WELWYN HATFIELD COUNCIL – DEVELOPMENT CONTROL
DELEGATED REPORT

APPLICATION No:	S6/2007/0422/MA
------------------------	------------------------

The proposed development would involve the demolition of an existing single storey prefabricated extension and the construction of a part single and part two-storey rear extension to accommodate a 13 new bedrooms and an associated accommodation. The proposed extension would be L-shaped around a court yard area.

Drawing Title : Proposed Site Plan

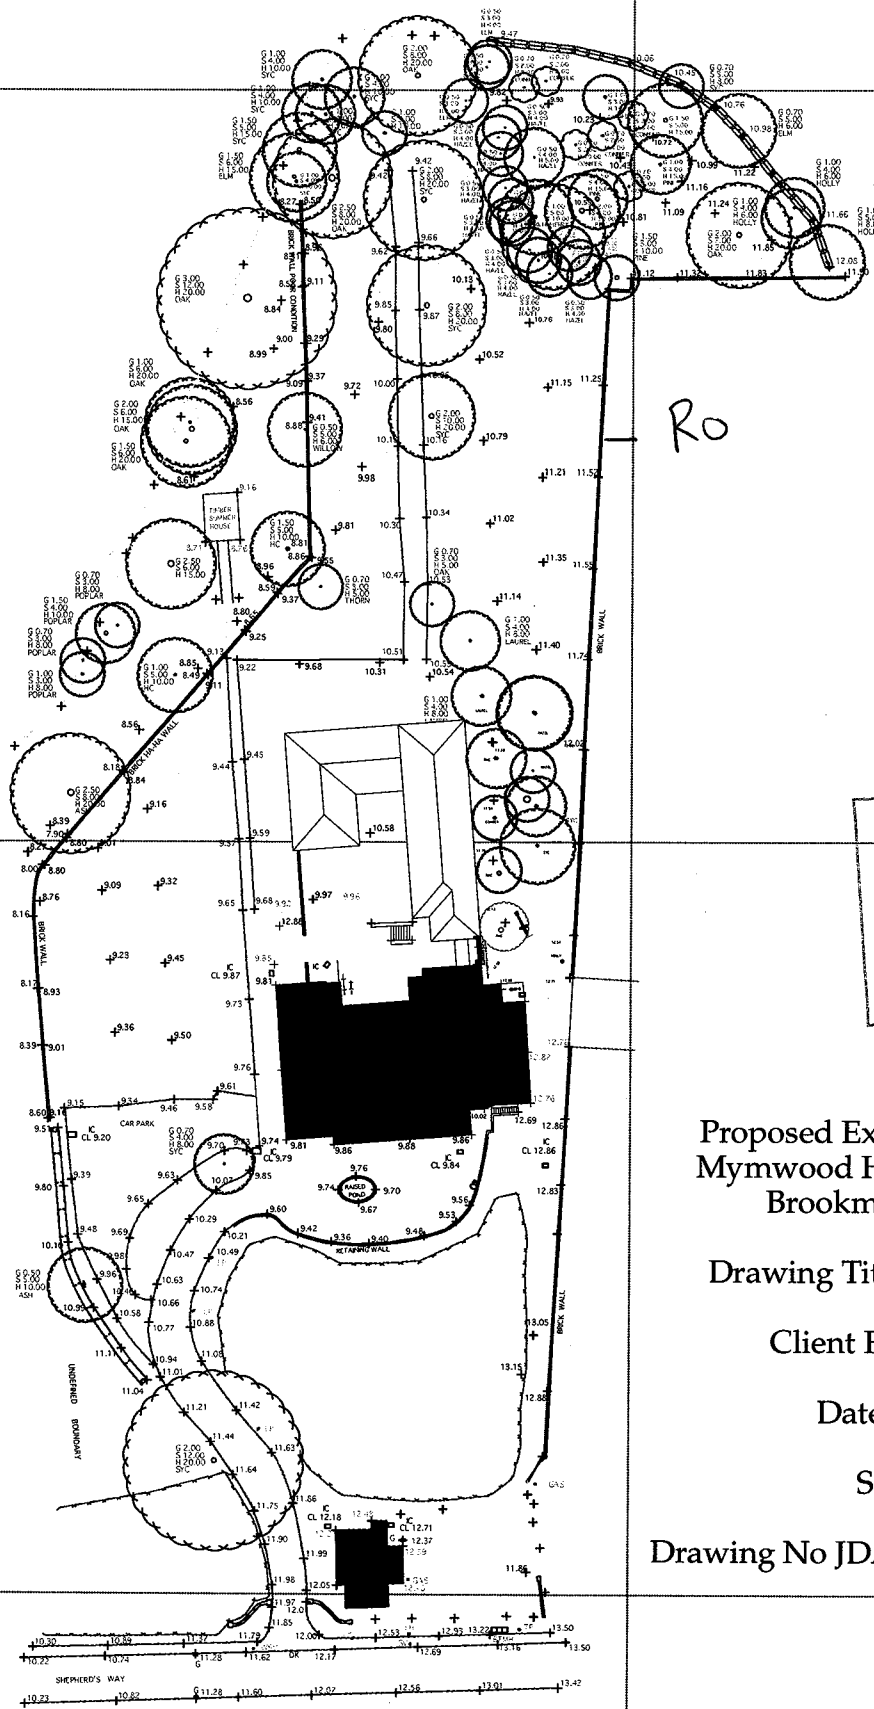
- the proposal affecting the view from the adjacent property and the of the countryside
- the proposal affecting the appearance of the existing building
- the boundary not being shown correctly on the submitted plans
- the size of the extension being too large within the Green Belt

The eastern flank boundary slightly differs between plans. The neighbouring property has stated that one of the plans does not show the land that is now in their ownership and resulted in a straighter boundary. The variation in boundary position has been taken into account within the assessment of the application and it would not alter the situation between the proposal and neighbouring property.

Date: January 2007  
Drawing: Proposed Elevations  
Scale: 1:100  
Ref: Final Design - dwg 2

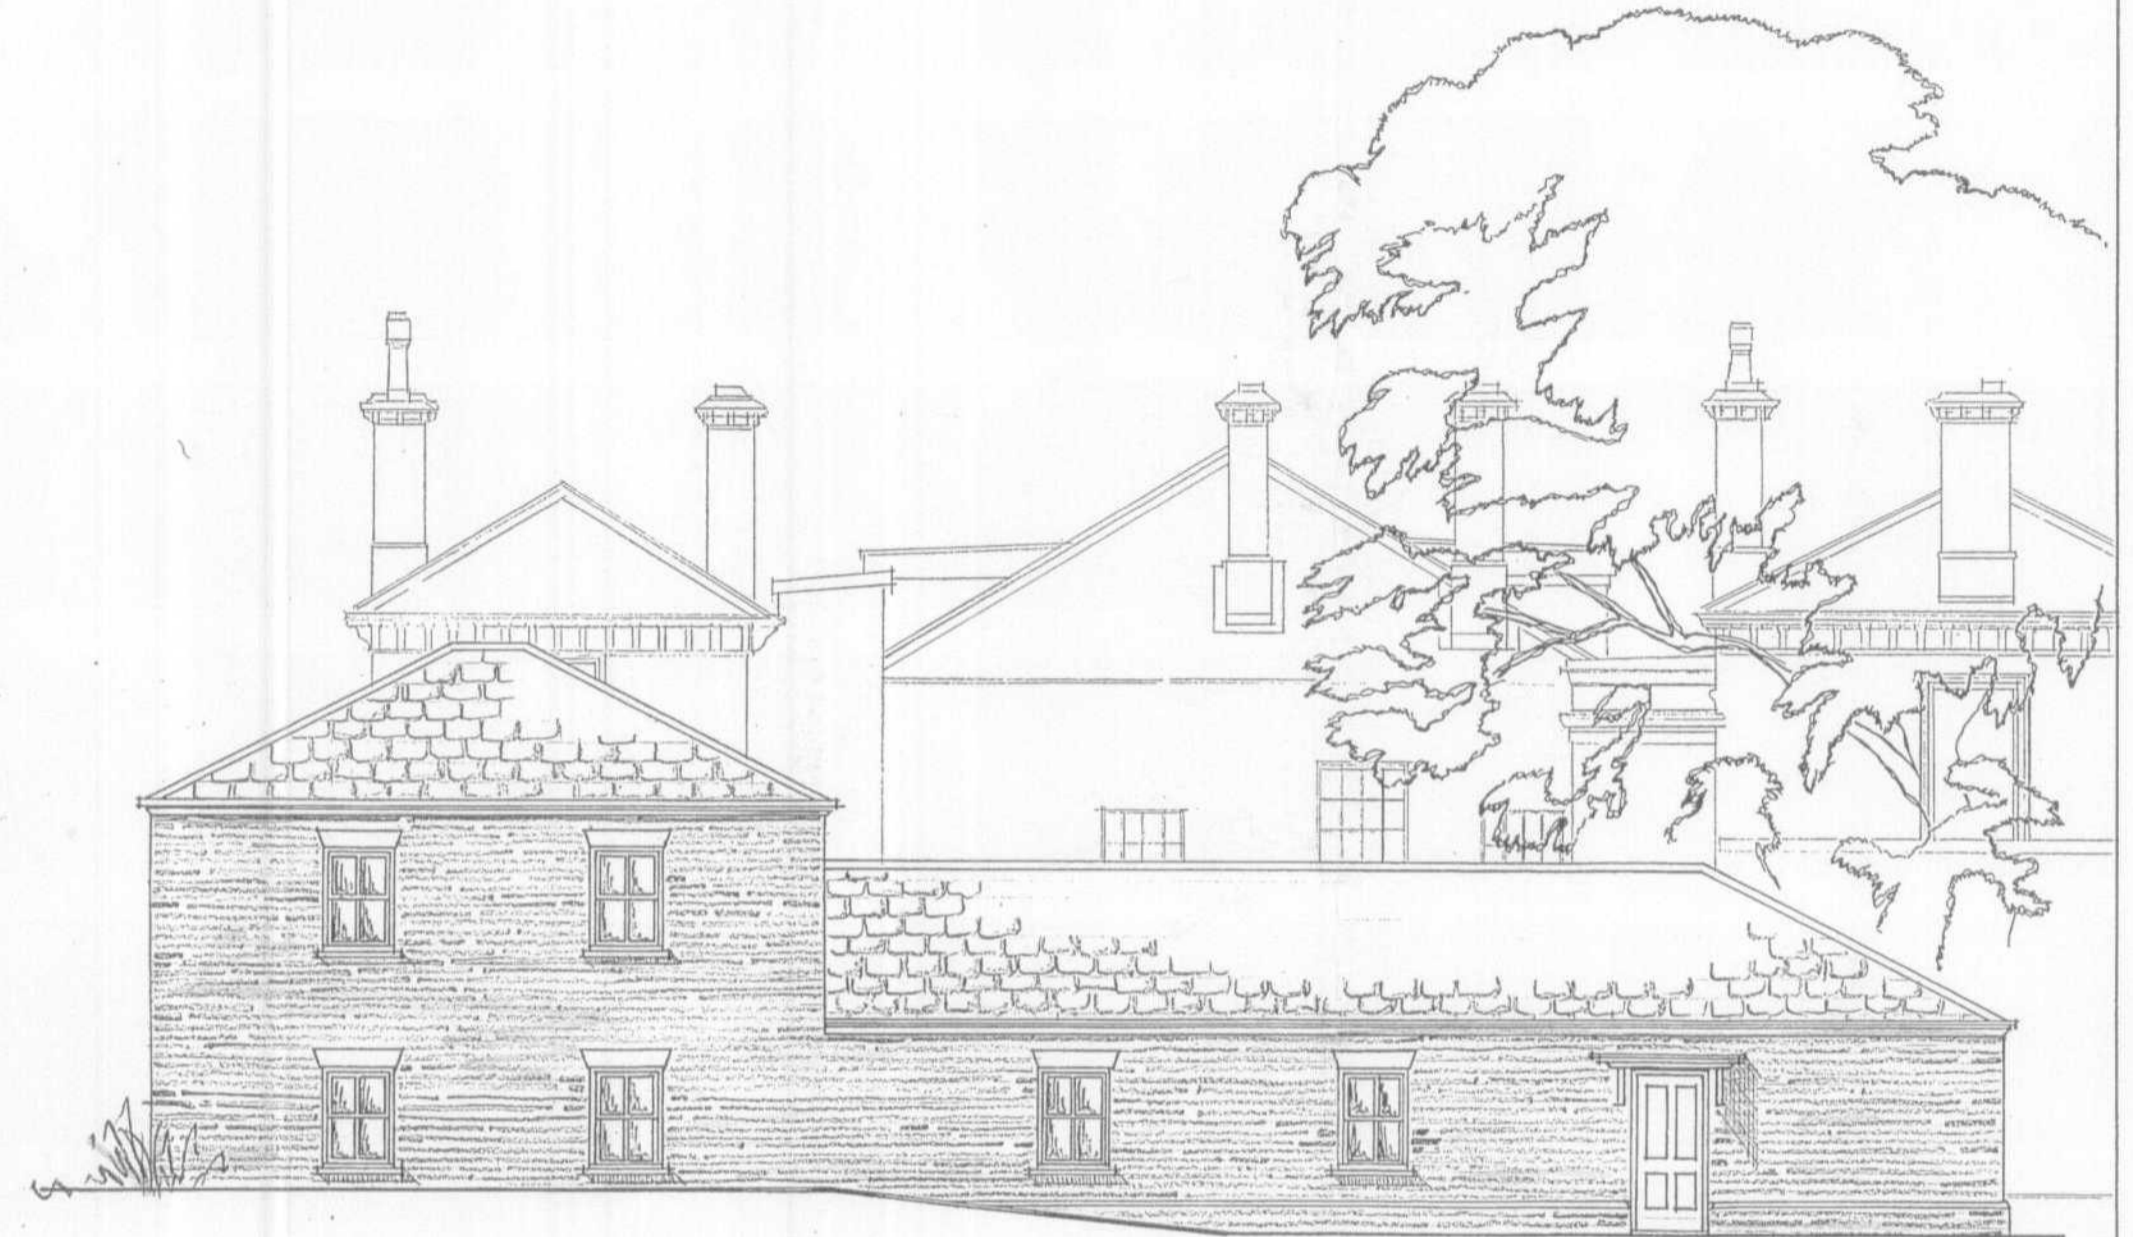
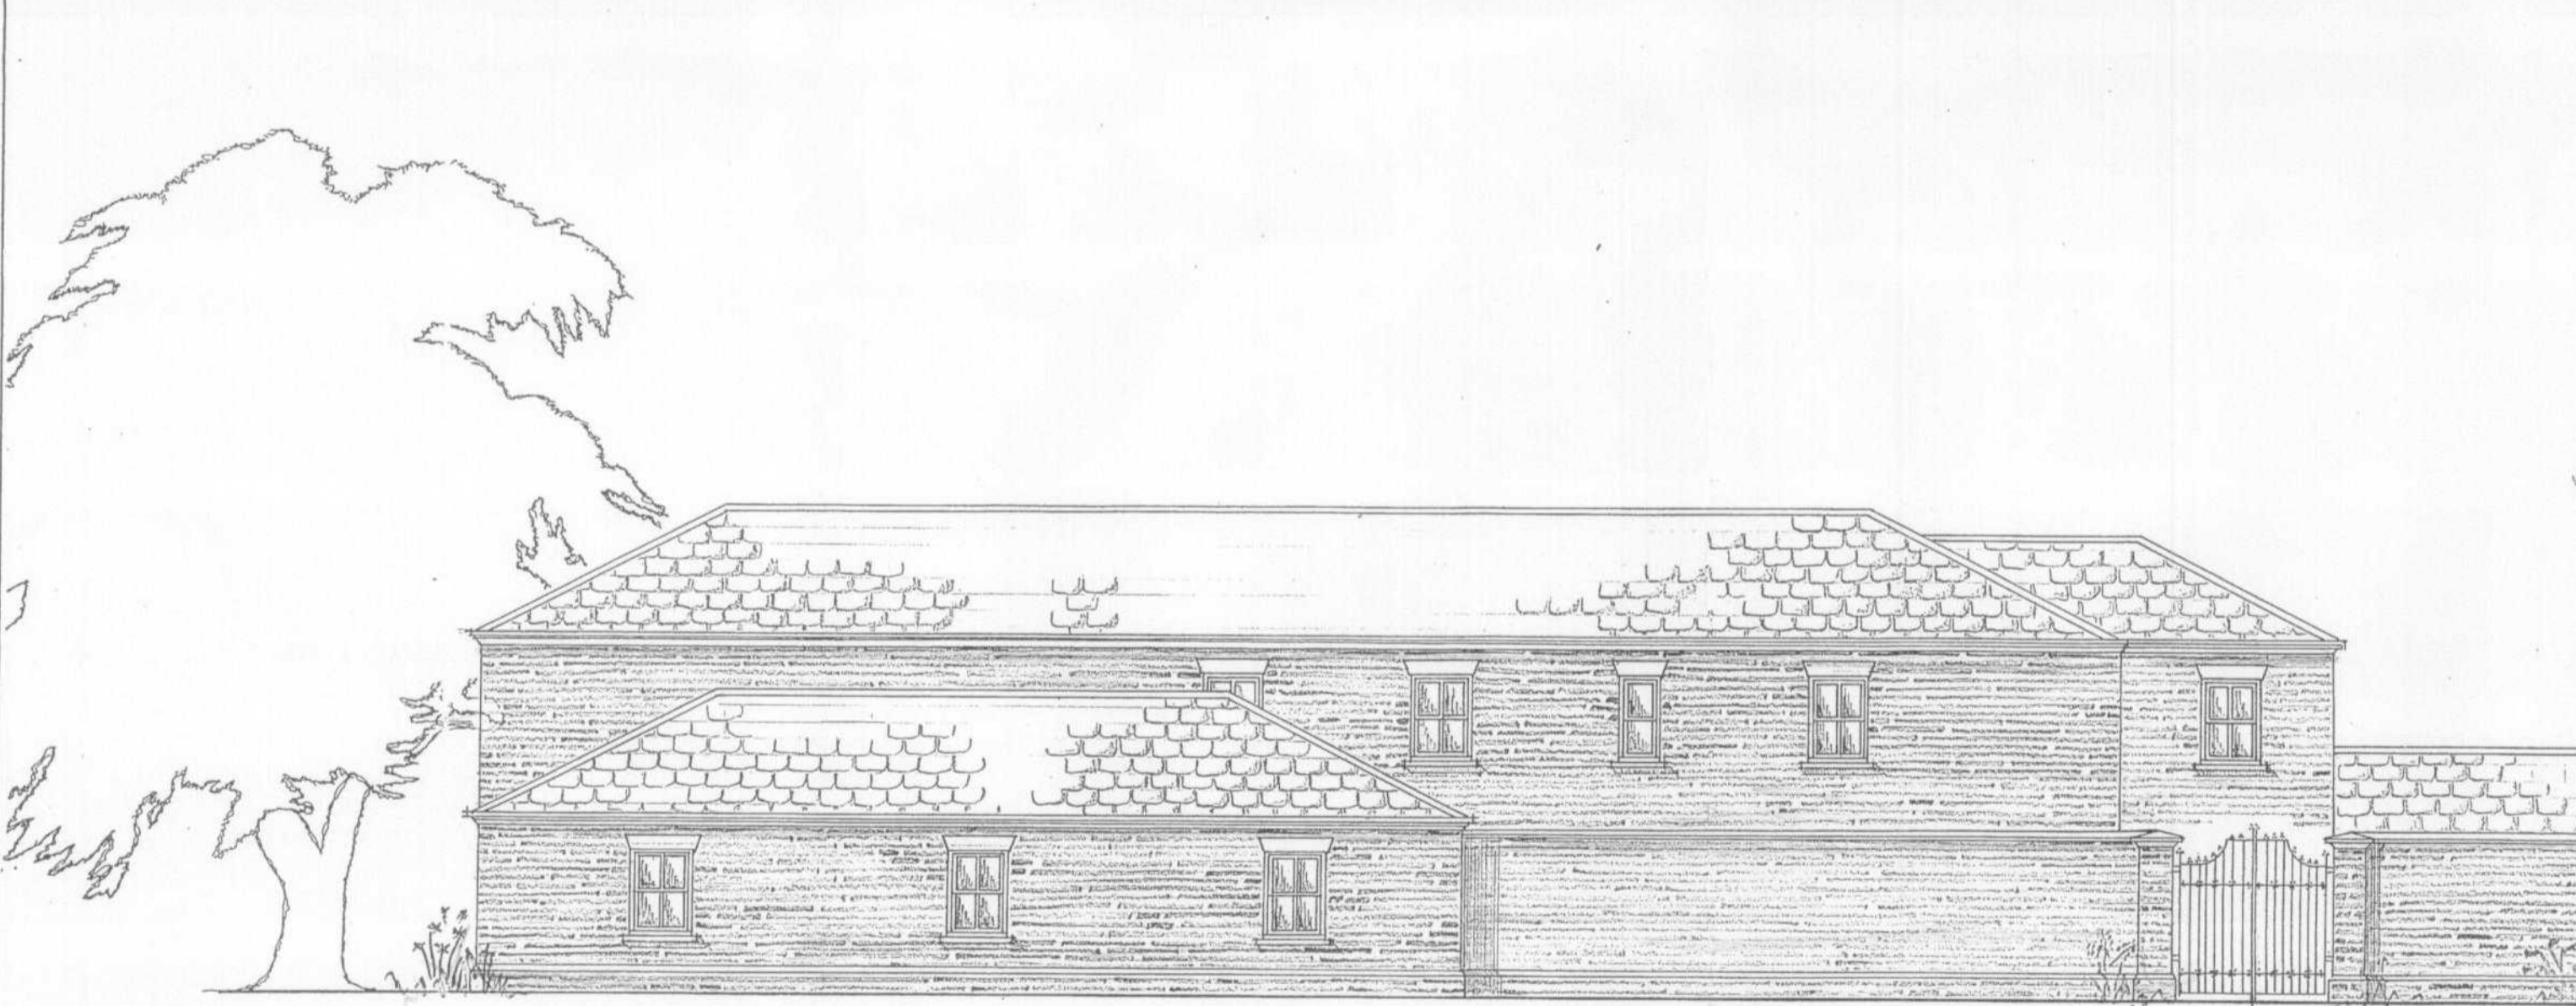
The Conservation Officer (Beams) – Amended plans were suggested which overcame the main concerns. Minor additional alterations have been requested to alter the window heads and arches to be brick rather than haddenstone and this alteration is to be conditioned.

- 2) The western elevation of the building has an imposing Italianate character, which is considered to be an important feature of the building and its listing. The proposal has been amended to respect existing western elevation by not having a large structure adjoining the western side of the building. The proposed dwarf brick wall and railings to the west would separate the Listed Building from the proposal and allow the main building to remain the dominant feature. The first floor areas of the proposal would be timber clad to break up the appearance of the proposed building, ensuring that it would not appear overly dominant. From the front of the building the proposed development would not be viewed and would not affect the appearance of the existing building. To the east of the site the existing building does not have as great importance as the western elevation. When viewed from the east the proposed development would appear subordinate to the main building and would only be connected by a single storey link, which is considered to be acceptable. The proposal would therefore comply with Policy R25 of the Welwyn Hatfield District Plan 2005.

1. C.2.1 – Time Limit Full Permission
2. C.5.1 – Material to be submitted
3. Notwithstanding the details on the approved plans, full details of amended elevations showing brick headstones and arches are to be submitted and approved in writing. Notwithstanding the provisions of the provisions of the Town and Country Planning, General Permitted Development) Order 1995 (or any Order revoking and re-enacting that Order with or without modification) no additional windows or similar openings shall be constructed in the flank elevation of the original dwelling and extension hereby permitted except for any which may be shown on the amended drawing(s) to be approved after the approval of this application.
